Changes to Paving at 343 Forest Avenue (Liberty Bay Recover Center)

Subject: Re: Changes to Paving at [343 Forest Avenue](#) (Liberty Bay Recover Center)

FENWICK ROAD PAVEMENT PLAN
SCALE: 1"=20'

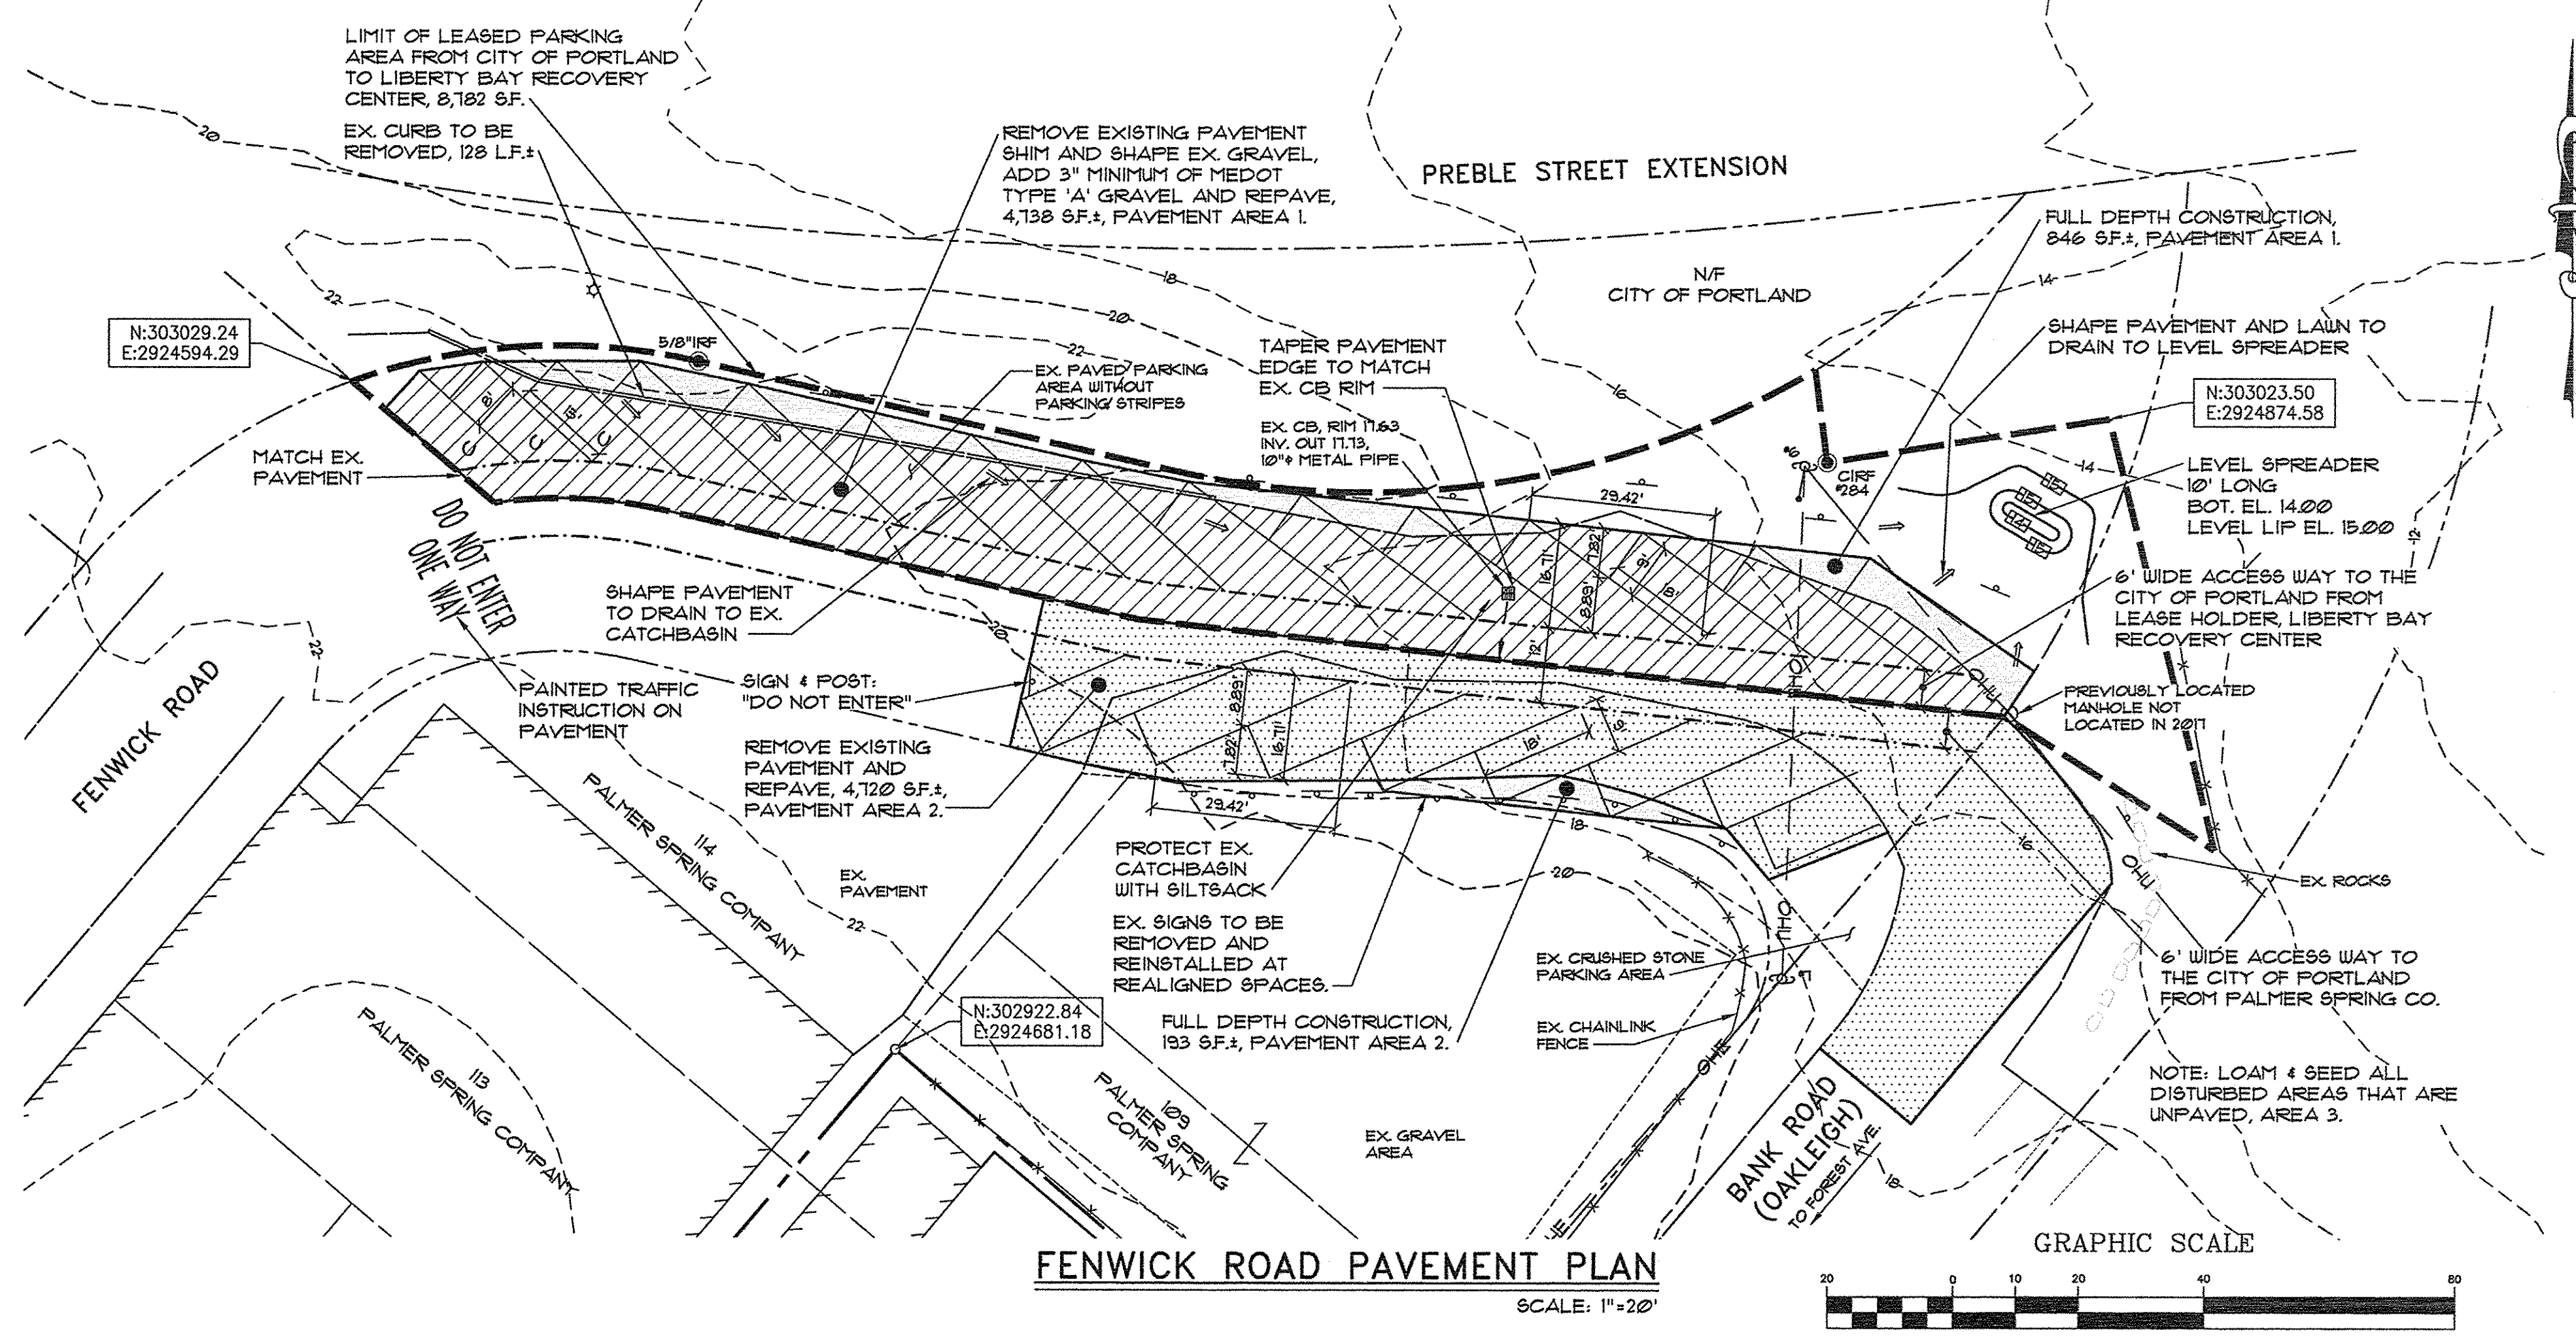
Visited this site today. I am not concerned about the few extra parking spots that they Incorporated, but there is some moderate erosion occurring at the edge of the pavement that should be repaired.

Also, I don't think we should ever be responsible for installing a fence at the edge of the ball field that they have chosen to park cars next to. If the tenant is concerned about cars getting hit, they should install the fence themselves.

See below from our Park Manager. He has approved the plan with the added restrictions around fixing the grass and that the City will not be responsible in the future for installing any fencing.
